**KIRKLEES METROPOLITAN COUNCIL
INVESTMENT & REGENERATION SERVICE**

Reference No: 2020/62/93973/E

Site Address: The Old Stone Yard, Near Bank, Shelley,
Huddersfield, HD8 8LS

Description: Erection of workshop

PROPOSED SITE PLAN

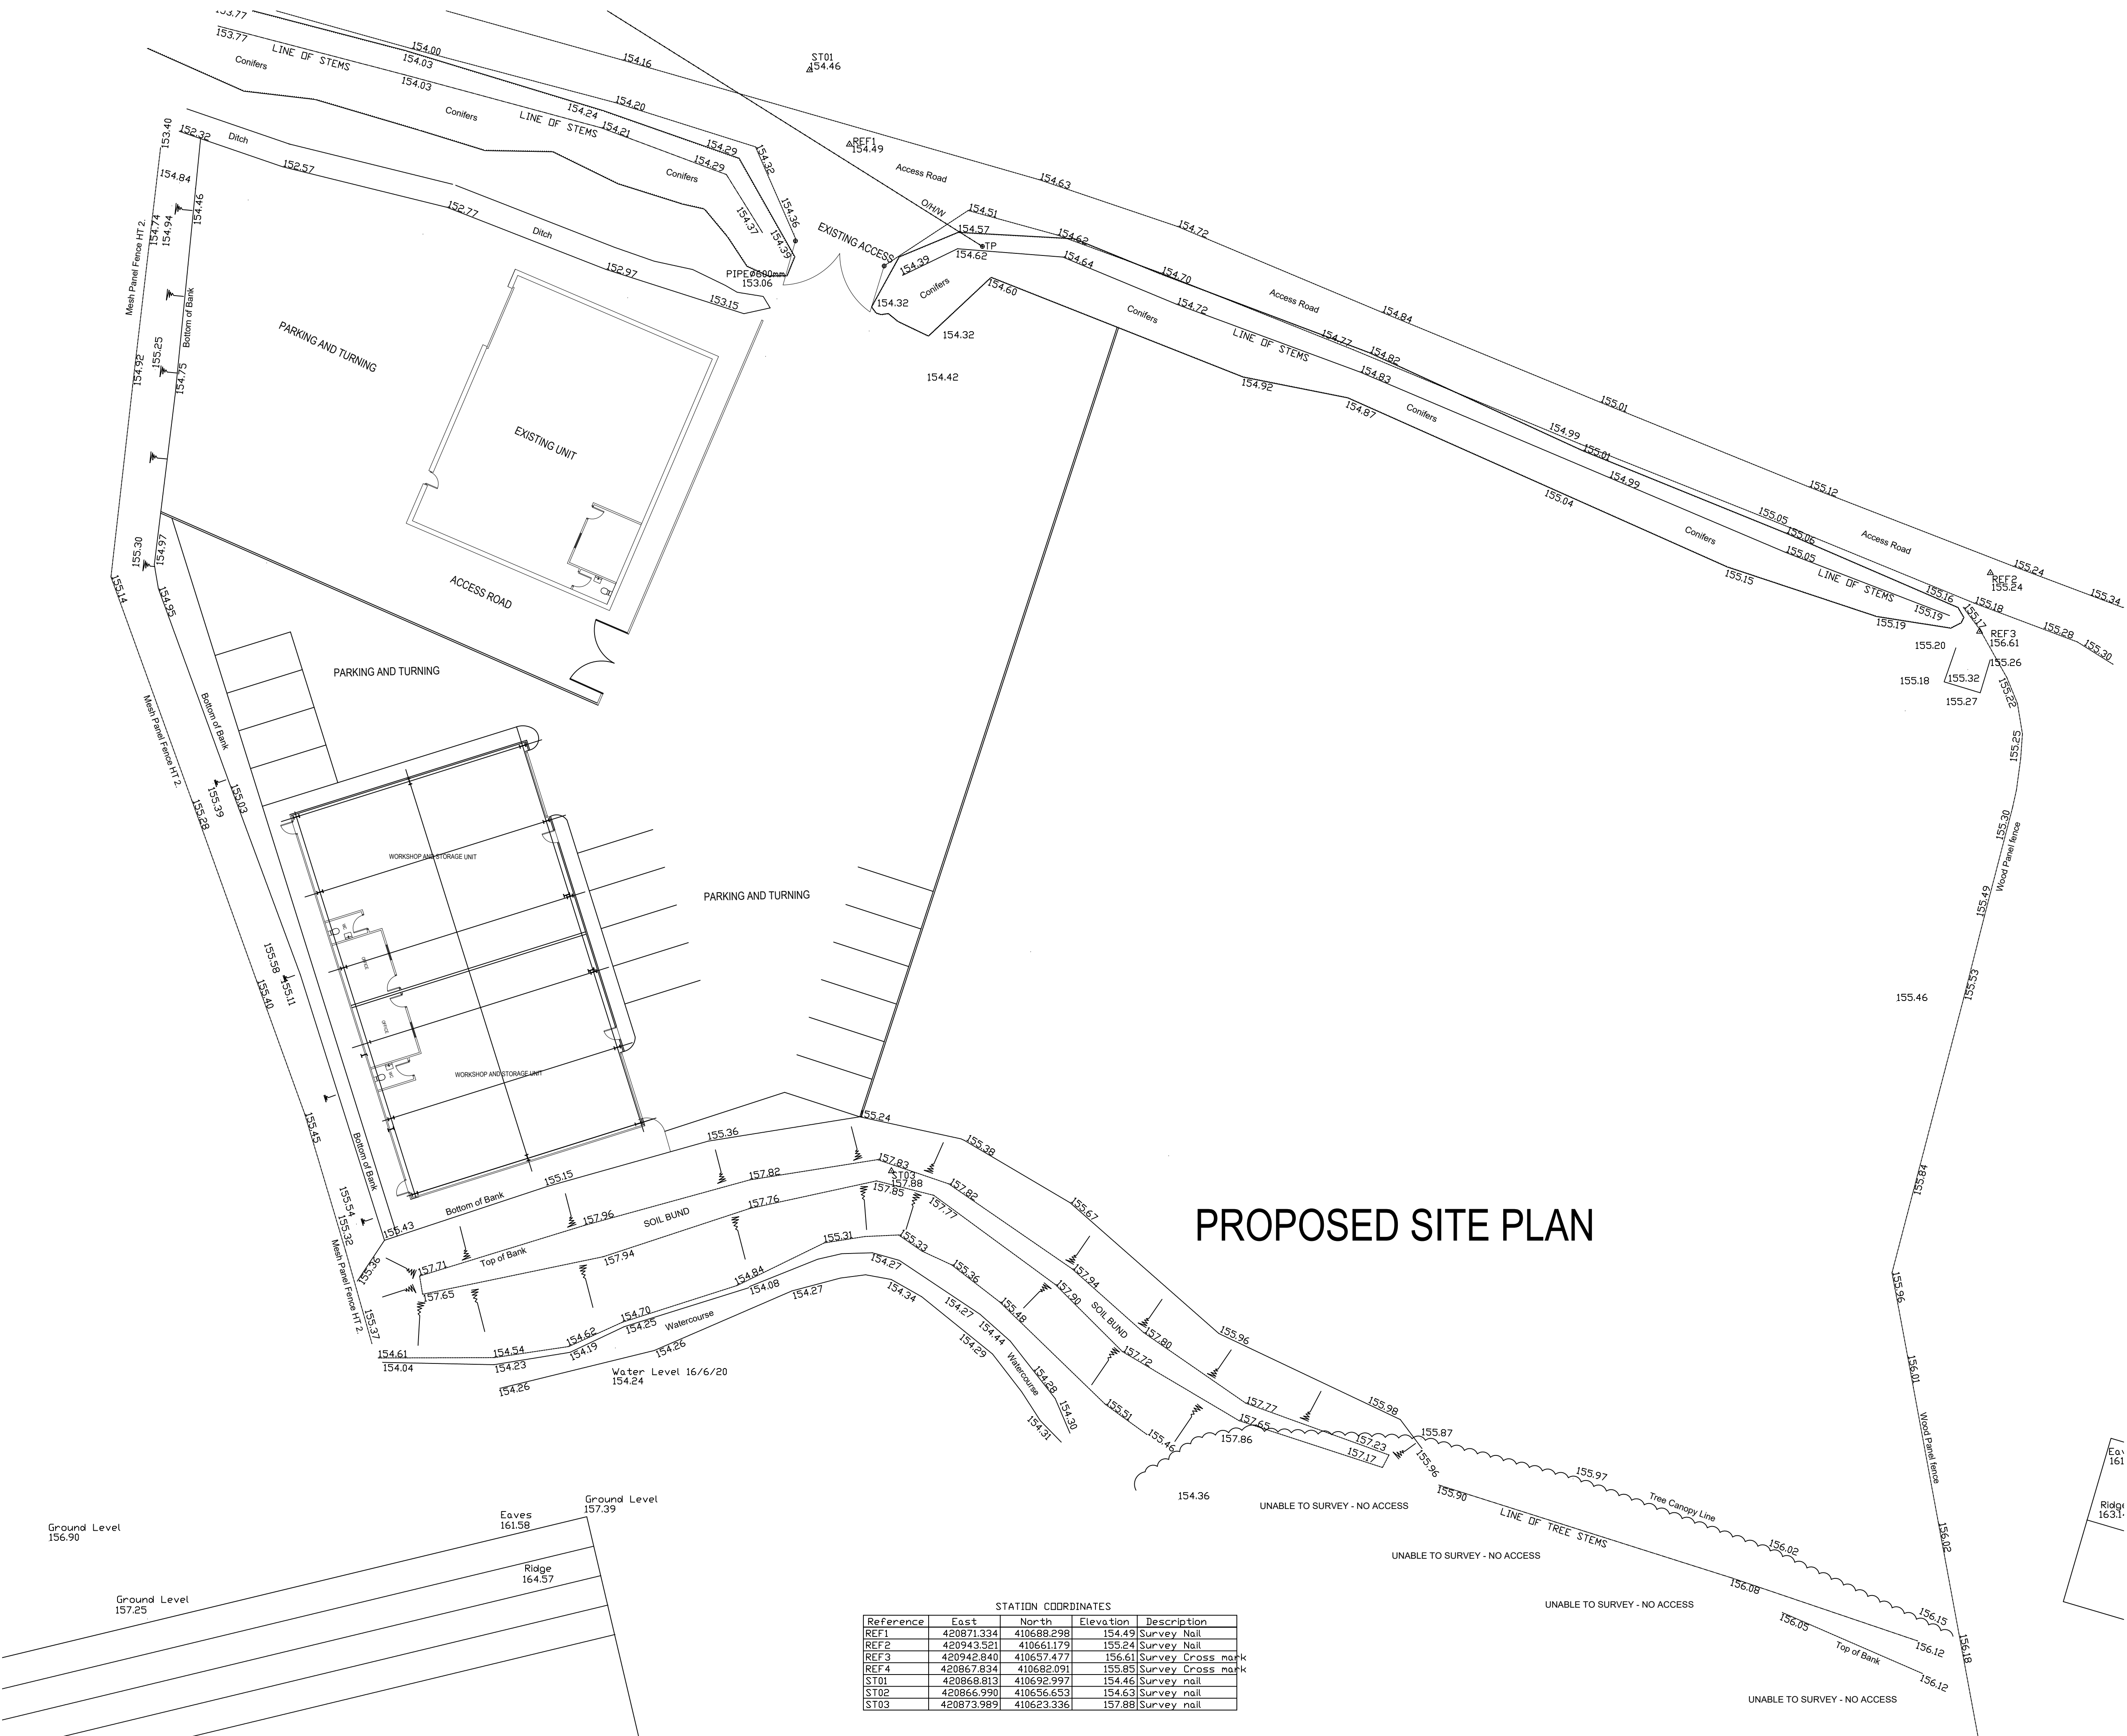
The proposed floor plan shows that the workshop would be sub-divided internally into 2 units. 14 parking spaces are shown on the proposed site plan. The proposal has been assessed by the Council's highways officers who gave the following comments:

These plans now show two proposed workshops with parking and turning areas, but no explanation is provided regarding the proposed end use.

This application provides insufficient information.

Can the applicants be asked to provide details of the proposed end use including the use class and anticipated traffic generation and parking demand.

Swept paths should also be provided to demonstrate that the largest vehicle anticipated to regularly use the access from Brook House Lane can enter and exit the site in a forward gear.

3. It has not been demonstrated that the proposed erection of a workshop would function safely in terms of highway safety as no information has been submitted regarding anticipated traffic generation and parking demand for the intended use, nor swept paths to demonstrate that the largest vehicles anticipated to regularly use the access from Brook House Lane can enter and leave in a forward gear. This is contrary to policy LP21 and LP22 of the Kirklees Local Plan and the aims of the National Planning Policy Framework.

CLIENT			
BENEFICIAL APPLICATIONS LTD			
PROJECT			
PROPOSED NEW INDUSTRIAL UNIT NEAR BANK PARK NEAR BANK SHELLEY			
DRAWING TITLE			
PROPOSED FLOOR PLAN			
Rev.	Notes	Date	Drawn
SCALE		1:50@A1	11.20 AD
PROJECT No.		DRAWING No.	Rev.
1622		204

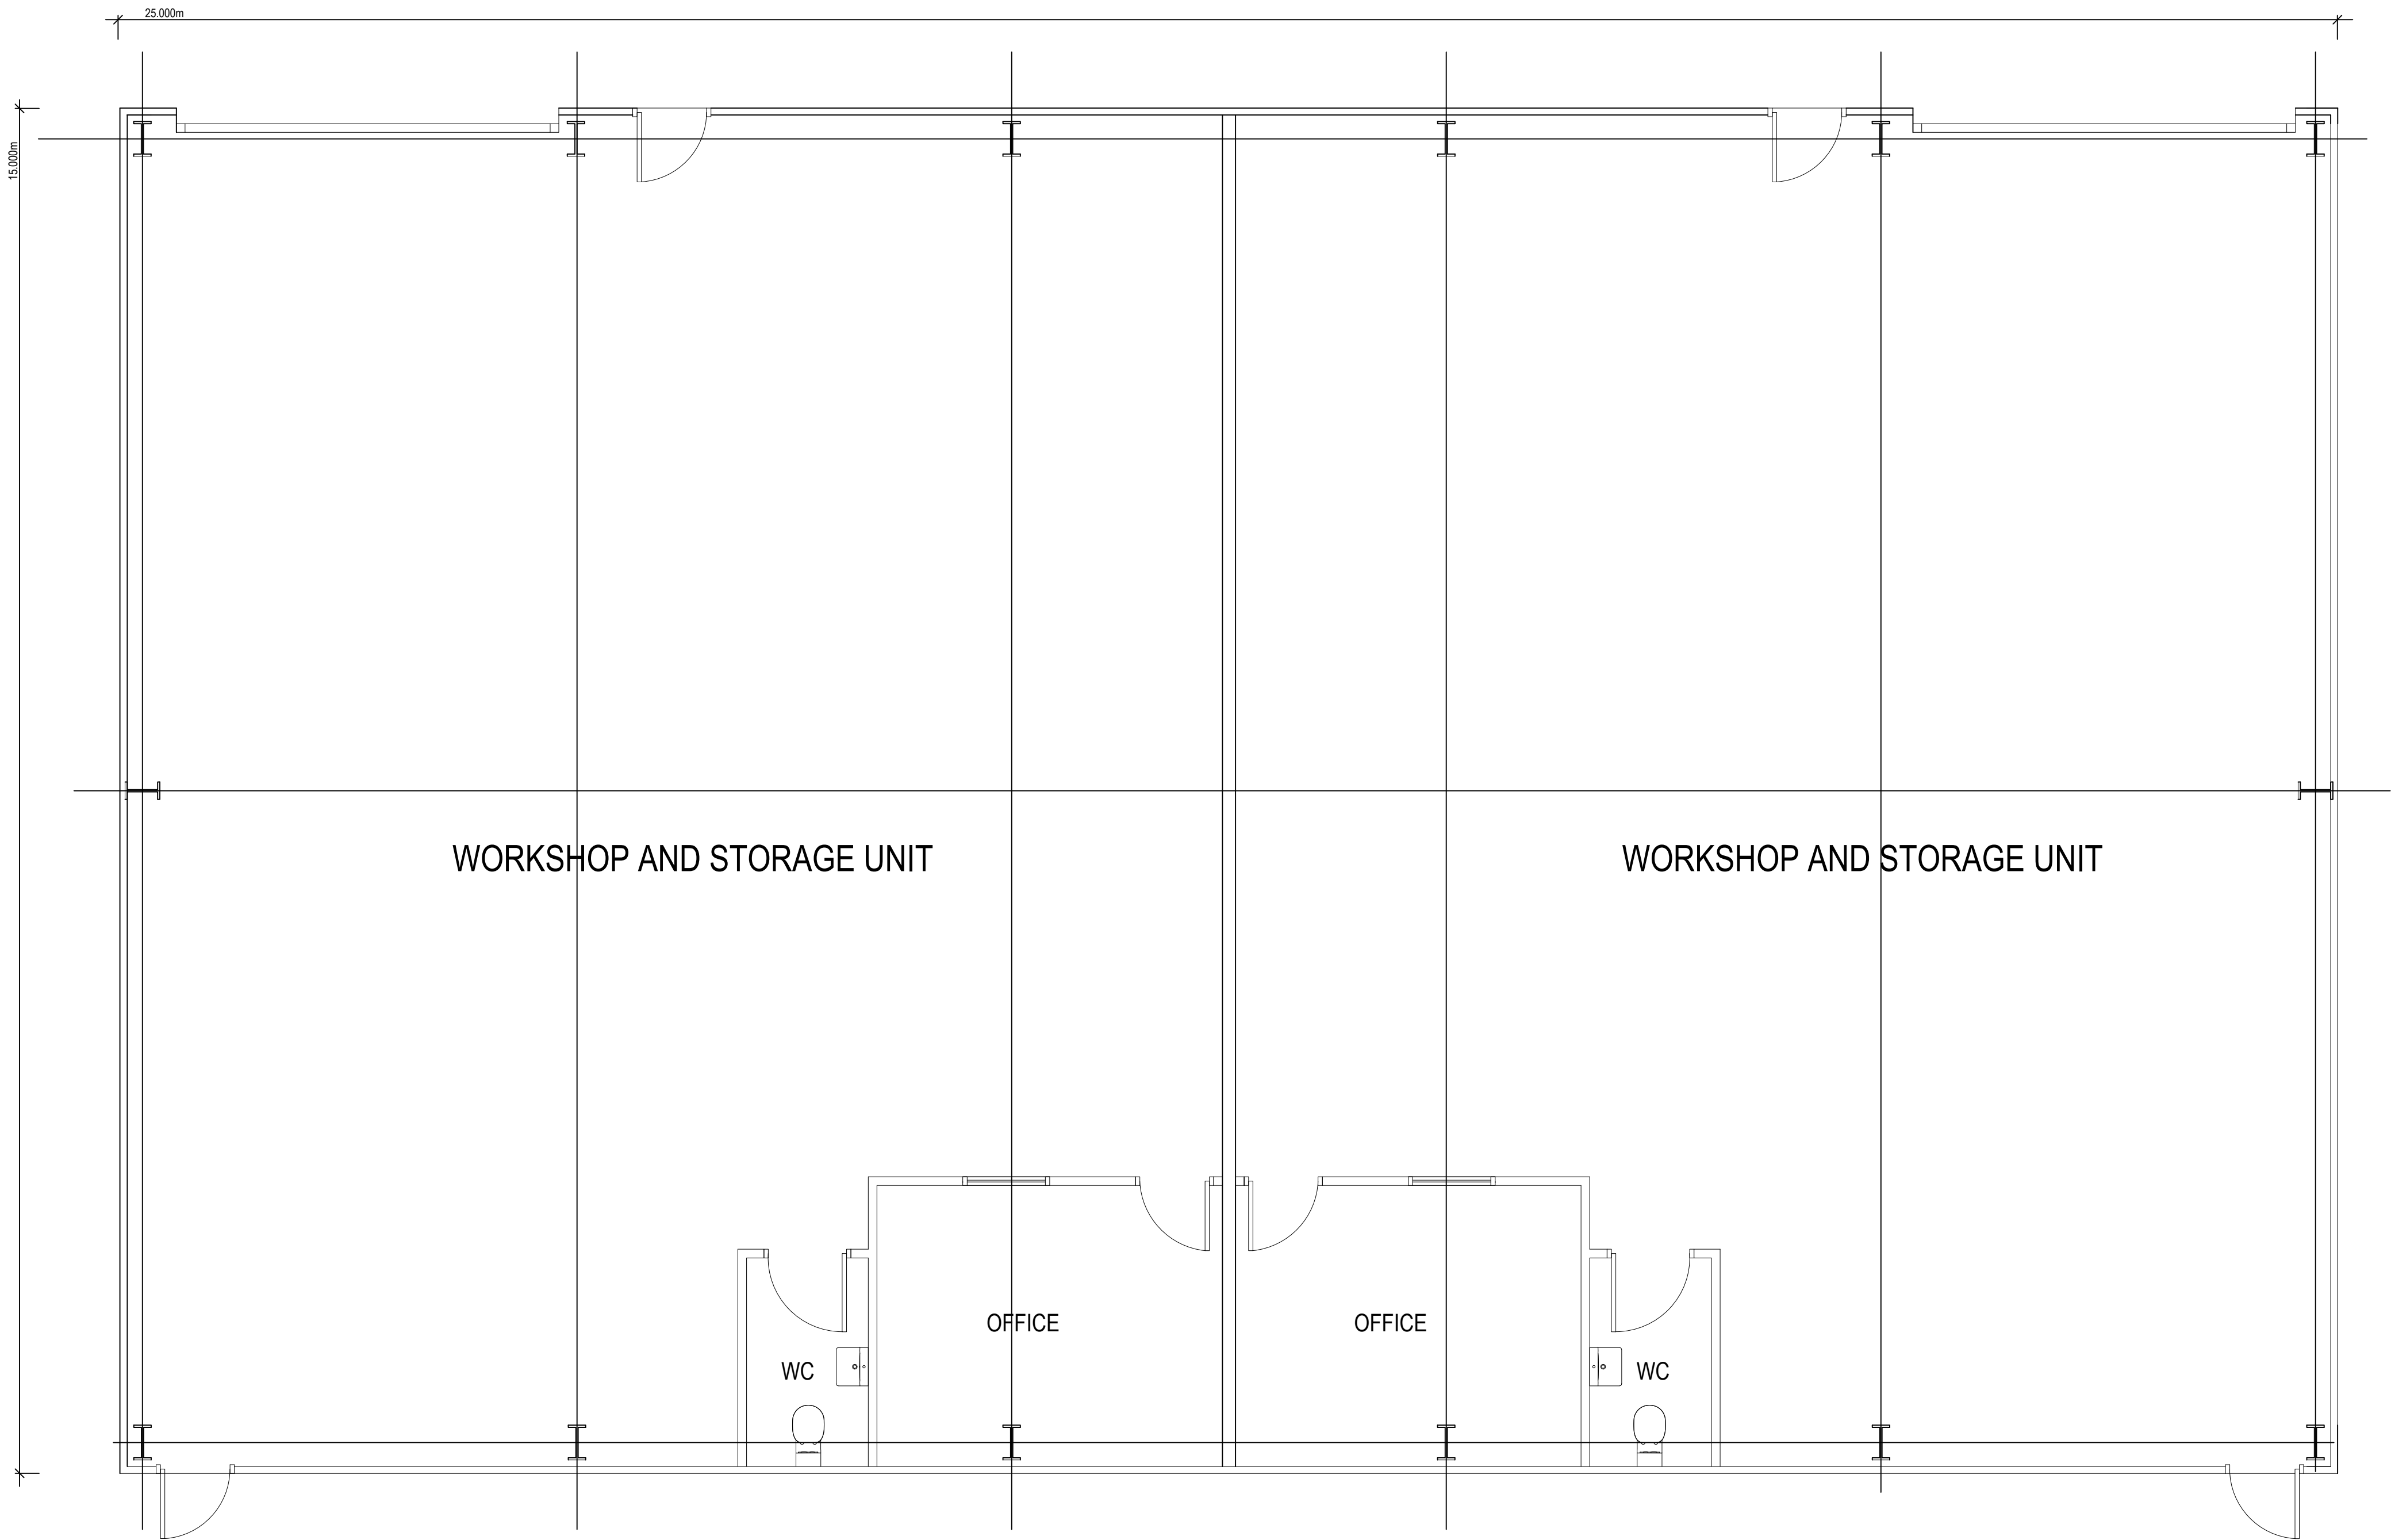
The proposed workshop which is the subject of this application (ref: 20/93973) would have a footprint of around 375 sqm and volume of 2250 cubic meters. The walls and roof would be predominantly profile metal cladding with 2.0m high coursed natural stone on the front elevation.

In officer's opinion the proposal by virtue of its size and scale would not respect or enhance the open character of the landscape and as such is contrary to policy LP24 of the Kirklees local plan.
